BOTLEY WEST SOLAR FARM (BWSF) REF: EN010147

VALE OF WHITE HORSE DISTRICT COUNCIL

RESPONSE TO ISSUE SPECIFIC HEARING 1, ACTION POINT 17

Map 1 Important Views in Cumnor Parish

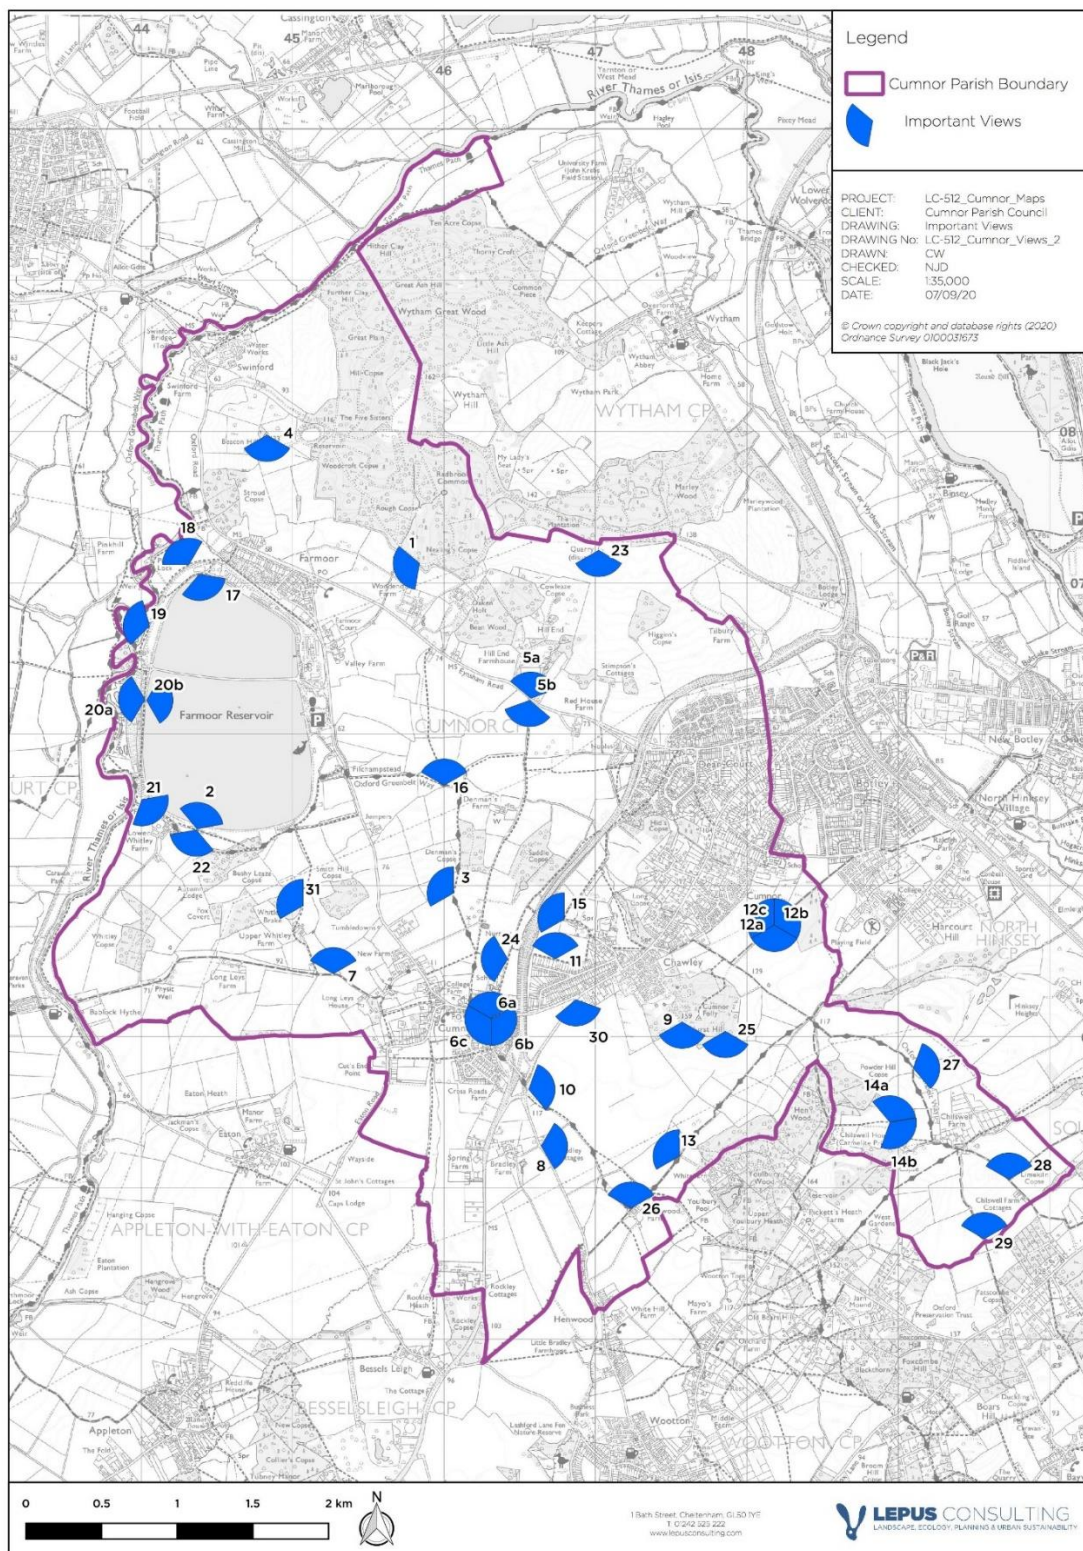
There are several places where views have not been taken, including those highlighted in the Cumnor Neighbourhood Plan such as Viewpoint 5b, 12, 23, 7, 12 and 17. These are highlighted on the plan extract below along with additional Prow, roads, and the Wytham permitted path network. Additional viewpoints are requested from these locations. Once the Substation ZVT is undertaken there may also be additional viewpoints that need to be included.
